Dean Moor Solar Farm

Environmental Statement: Chapter 7 – Figure 7.6 1-5 Landscape Strategy Plan on behalf of FVS Dean Moor Limited

26 August 2025
Prepared by: Stantec UK Ltd
PINS Ref: EN010155
Document Ref: D2.28
Deadline: 2
Revision: 2

Project Ref:	EN010155/6.2 ES Figure 7.6.1-7.6.5 Landscape Strategy Plan
Status	Final
Issue/ Rev:	2
Date:	August 2025

- LEGEND**
- Order Limits
 - EXISTING FEATURES**
 - Existing Woodland/Scrub (Broadleaved)
 - Existing Woodland (Coniferous)
 - Existing Woodland (Out of Order Limits)

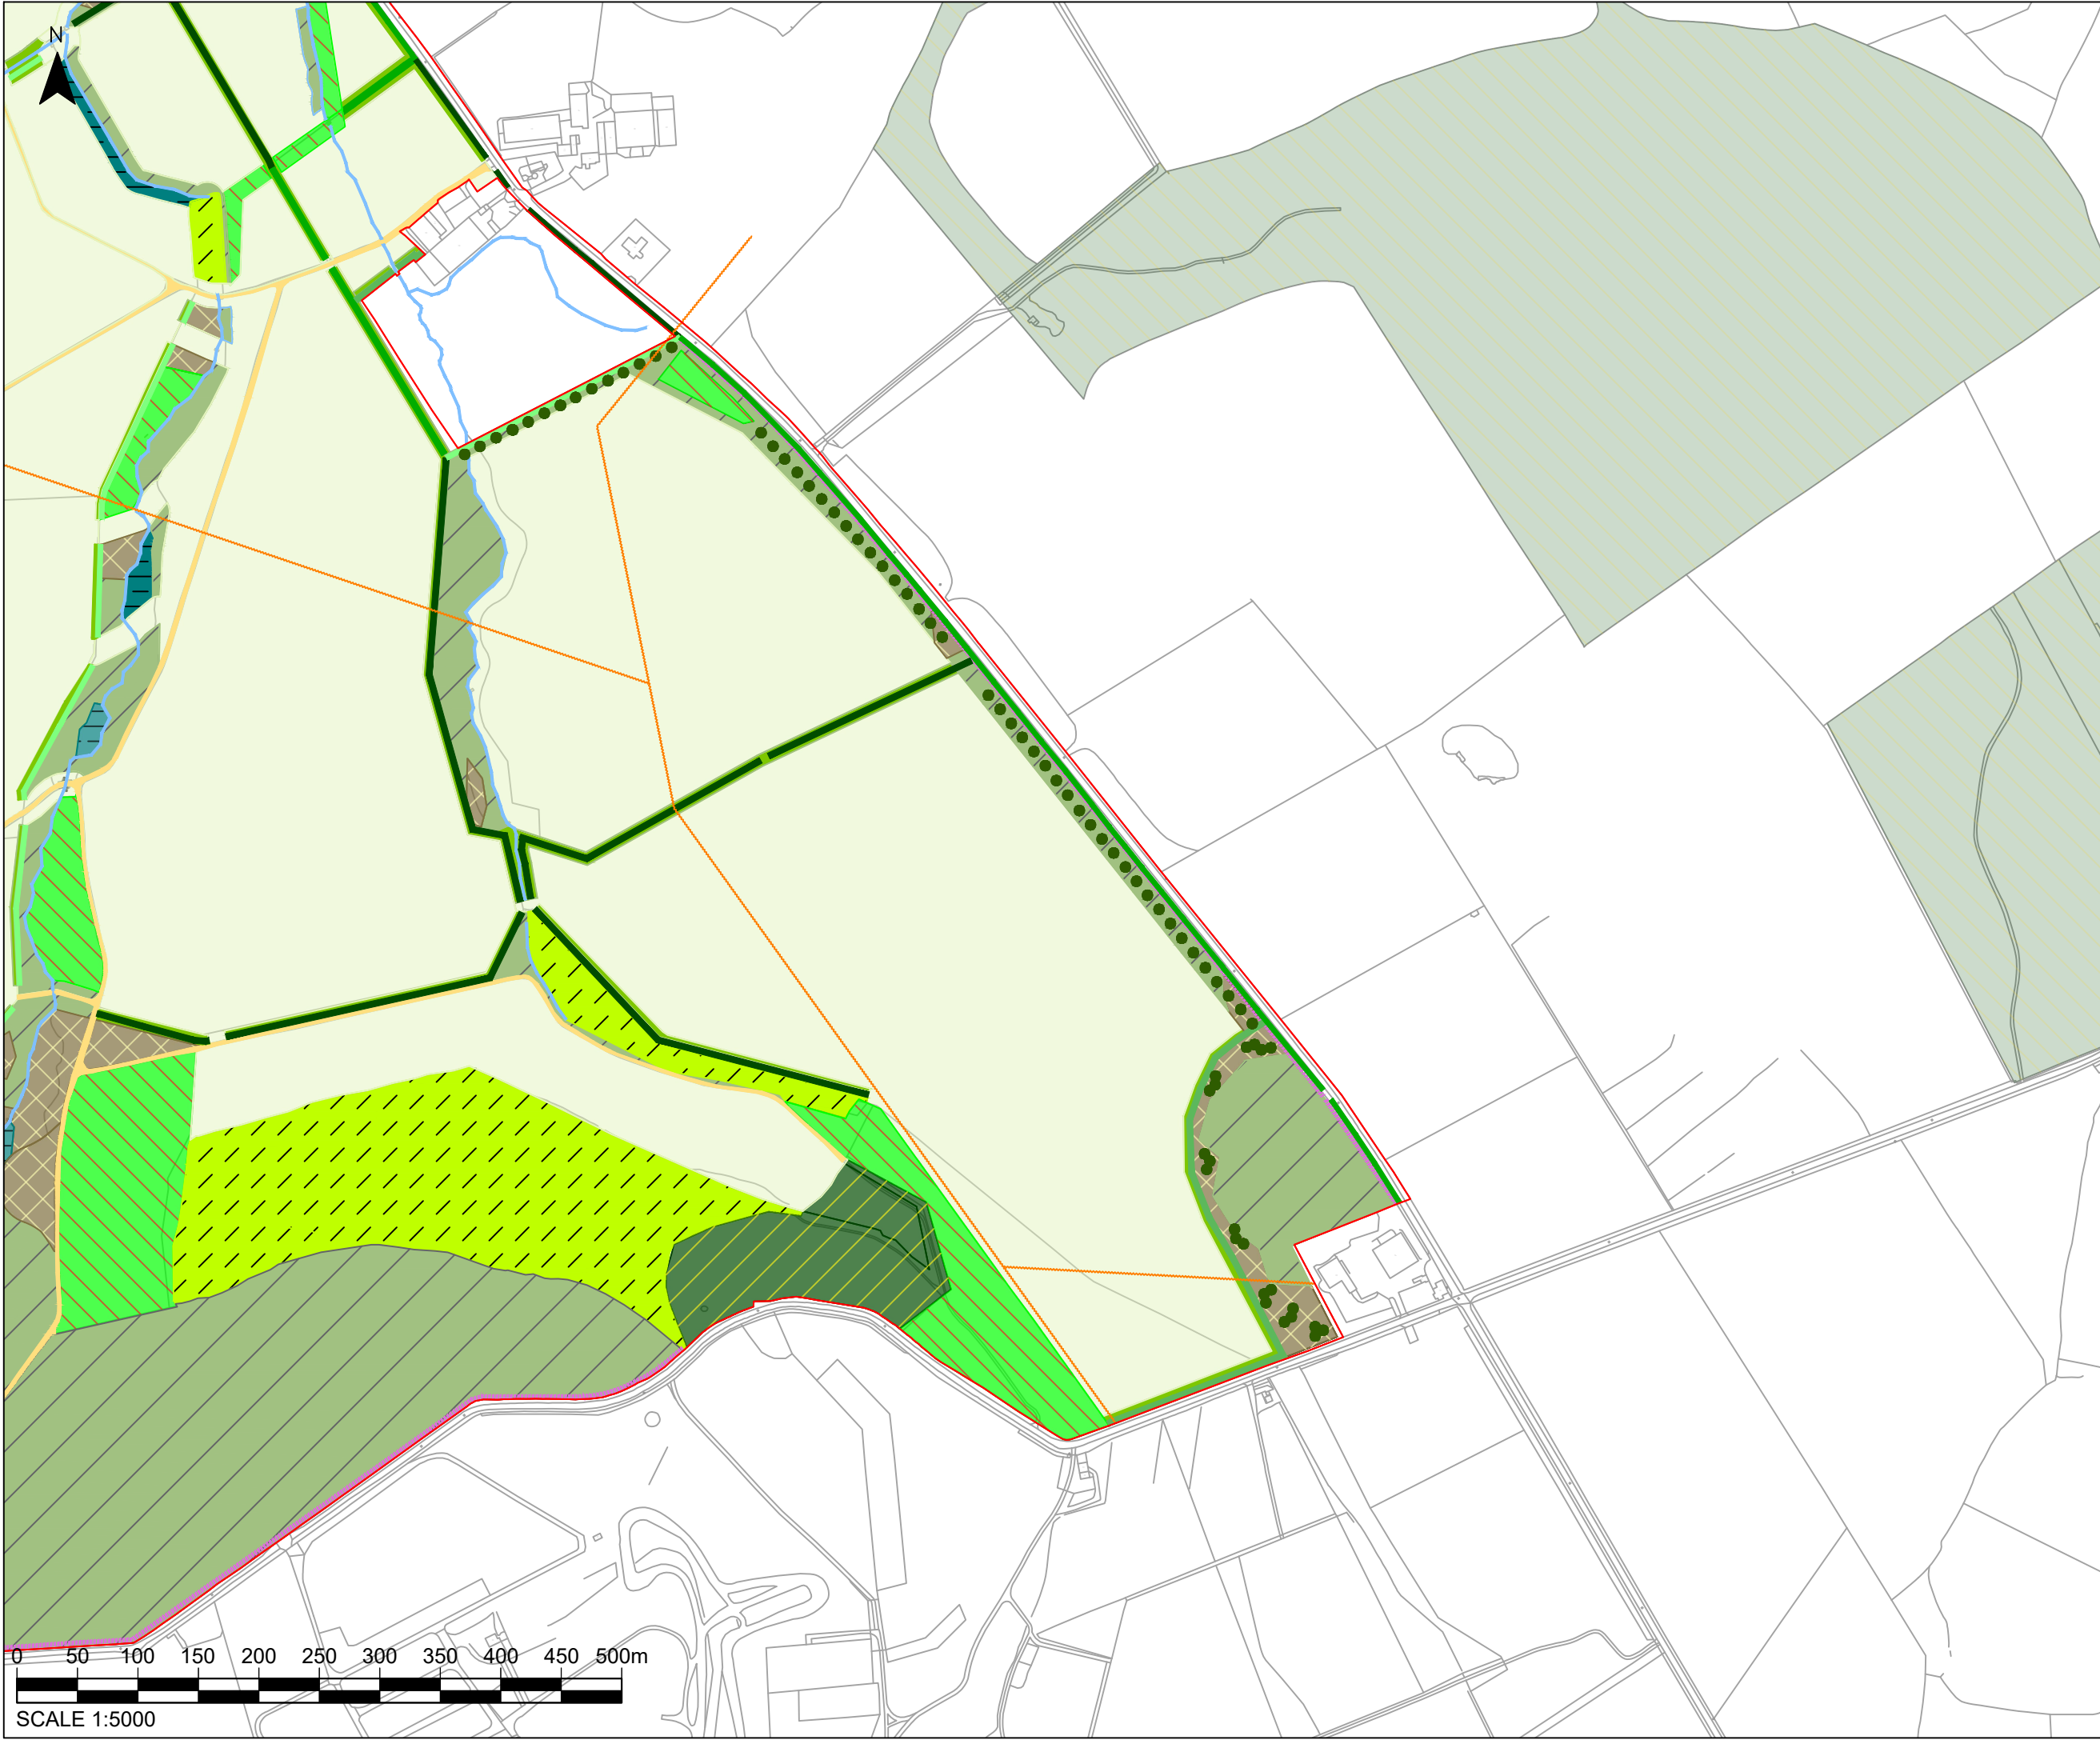
Revision	Reason
Dry stone wall line-style updated to darker purple and dashed	<p>Q6.0.2 of the Examining Authority's (ExA) first written questions stated:</p> <p><i>"The Landscape Strategy plan [APP-088] includes a number of colour coded features which are similar and difficult to discern (for example, existing and proposed hedgerows). Please amend."</i></p>
Willow screening hedge line-style changed to smaller dash and changed from green to reddish/brown	
Existing woodland (Coniferous) updated to crosshatch (easier to distinguish between coniferous/broadleaved)	
Acid grassland hatch changed to differentiate better between this and existing woodland	
Native planting to protect watercourse changed colour to darker blue	
Marginal planting hatch colour made slightly lighter blue to distinguish between this and native planting to protect watercourse	
All hedge line-styles/colours changed to make it easier to distinguish between them

Other grassland colour made lighter	
Broadleaf woodland hatch changed to distinguish better between grassland and woodland colours
